# CITY OF ALBUQUERQUE

**Re: Tuscany Village, Grading Plan**  
**Engineer's Stamp Dated 12-8-11 (E22/D007G)**

Based upon the information provided in your submittal dated 12-9-11, the above referenced plan cannot be approved for Platting action by the DRB until the following comments are addressed:

CITY OF ALBUQUERQUE
DEPARTMENT OF MUNICIPAL DEVELOPMENT
SAUVIGNON PHASE III / TUSCANY VILLAGE
GRADING PLAN

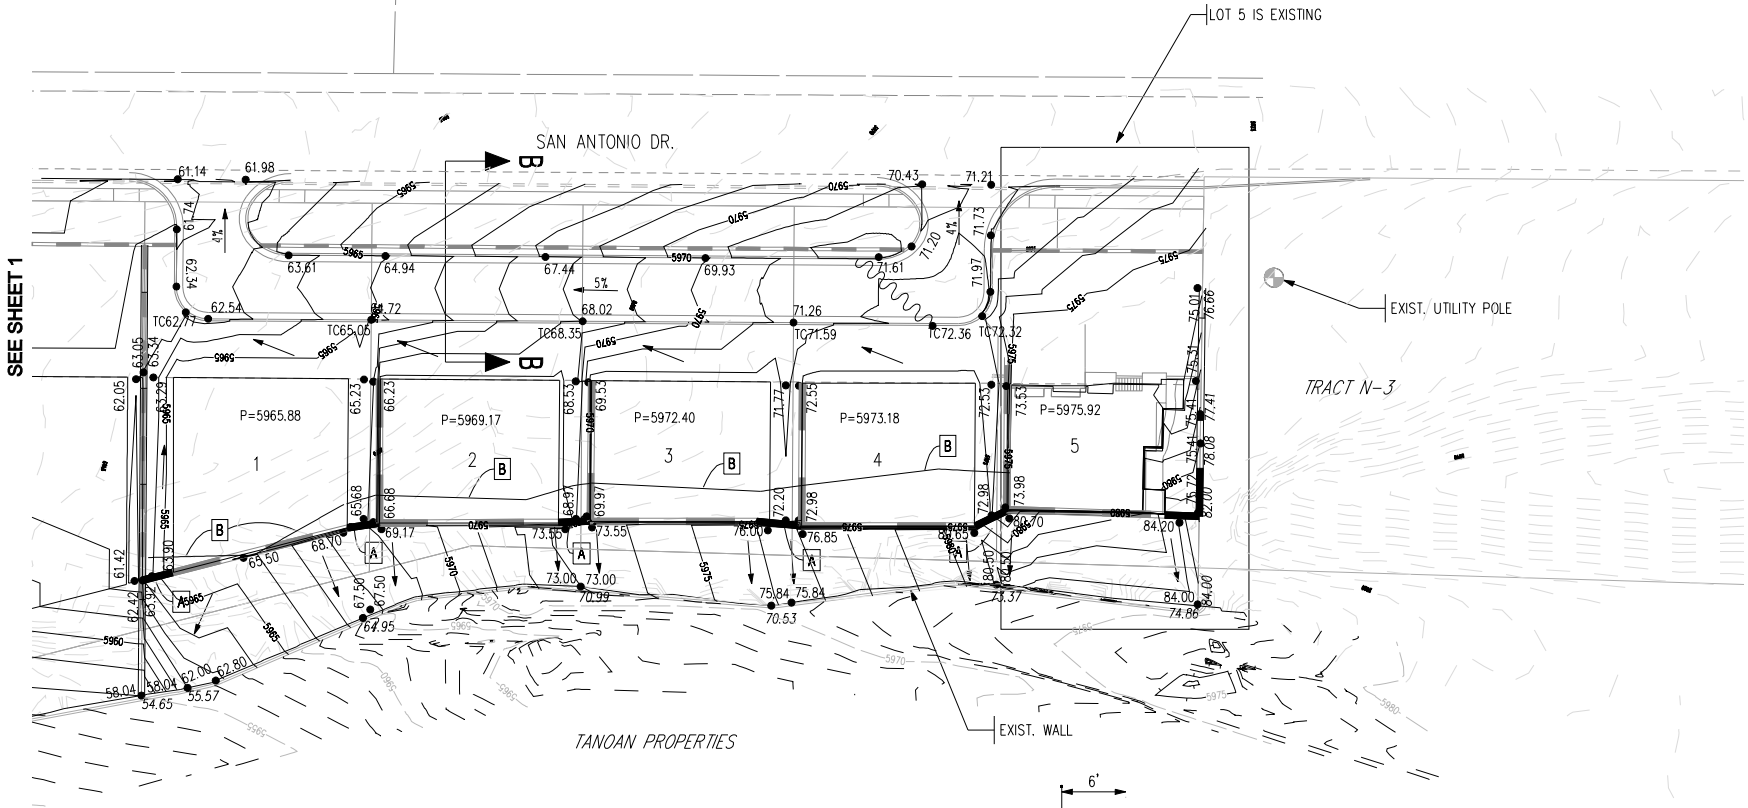
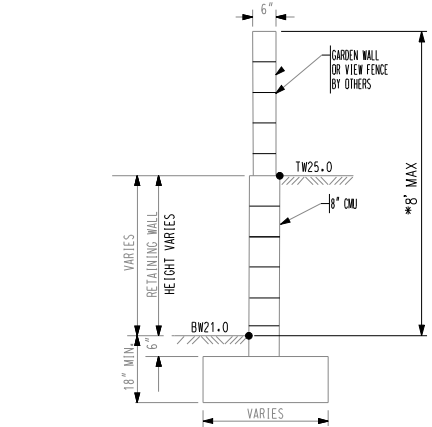
- This plan proposes grading on adjacent property to the south and has graded on adjacent property to the east to make it work. Provide written approval from adjacent property owners.
- Per our conversation 12-14-11, the intent is to construct the retaining wall between the pads at the time the houses are built. Add a note that the retaining walls are to be built by the home builder.
- The Grading Plan is to be certified and in substantial compliance prior to Building Permits being approved.
